OXFORDSHIRE COUNTY COUNCIL'S RESPONSE TO CONSULTATION ON THE FOLLOWING DEVELOPMENT PROPOSAL

Application no: 22/01682/F

Proposal: Development of a ground mounted solar farm incorporating the installation of solar PV panels, associated infrastructure and access, as well as landscape planting and designated ecological enhancement areas.

Location: Land North Of Manor Farm, Noke

Visibility Splays at Proposed Site Access

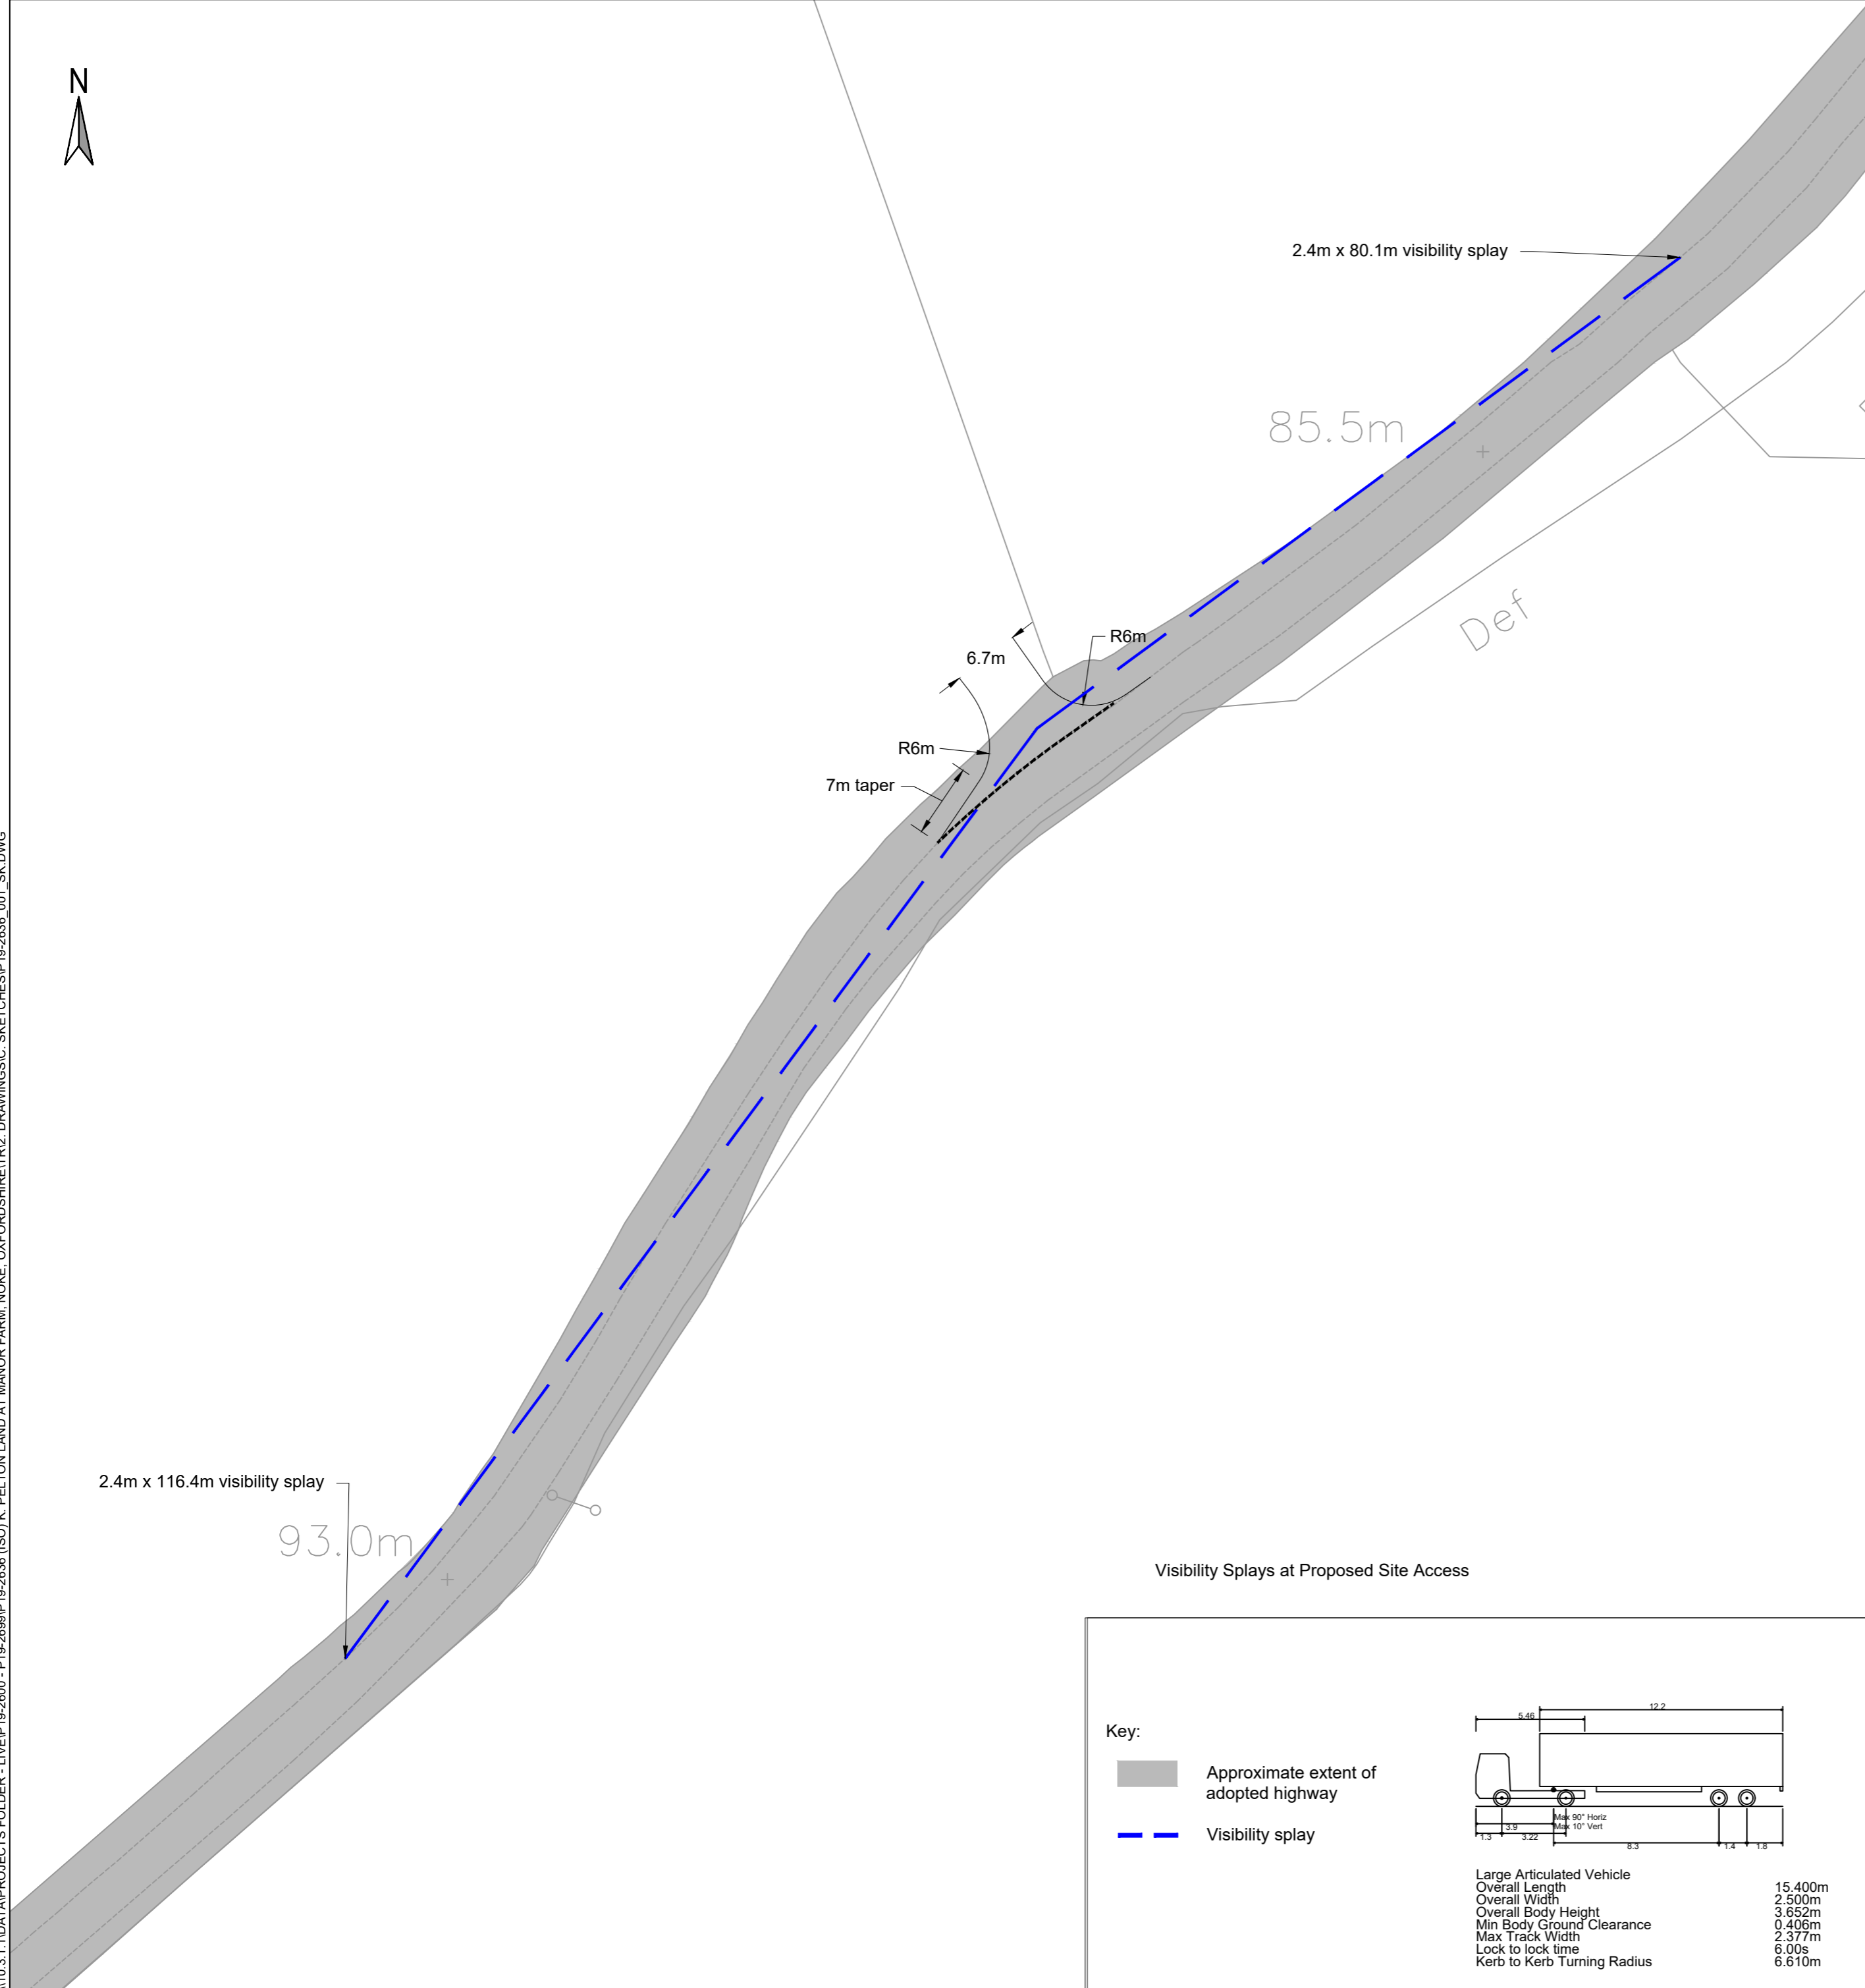
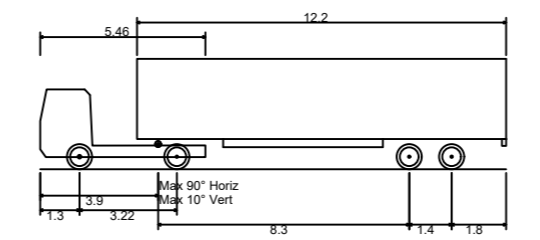
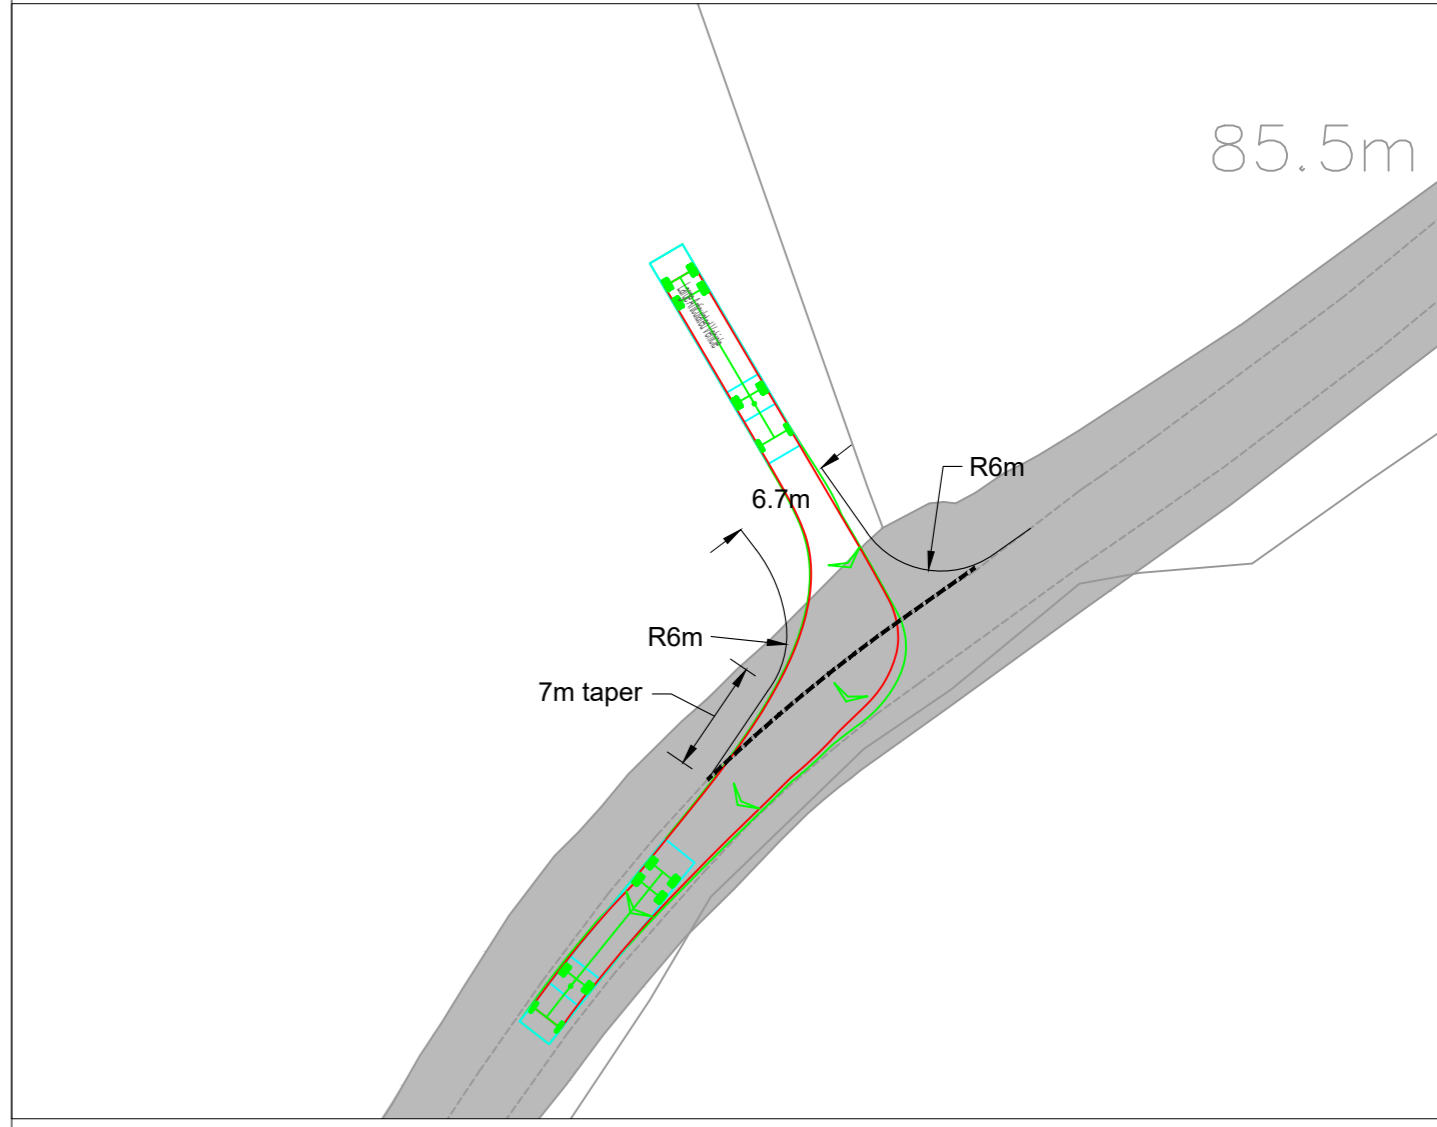
The CTMP suggests that banksmen will be able to stop westbound traffic leaving the village while an HGV exits the site, but the primary risk is eastbound traffic approaching in the National Speed Limit (60mph). The Proposed Site Access Arrangement drawing in the CTMP indicates that there is 116.4m of visibility splay to the south-west but this ignores vegetation growing over the highway boundary and the raised bank in the verge. I have measured the visibility splay to be 2.4m x 95m in this direction, which is very much lower than necessary for the posted speed limit.

The CTMP says that observed speeds are much lower than the NSL, but this must be quantified by an ATC survey to determine the actual 85%ile speed and, therefore, the required visibility splay. The ATC should be placed as near as possible to the furthest point of the visibility splay. Without this speed data, OCC objects to the proposal as a "safe and suitable access", as required by the NPPF, has not been demonstrated.
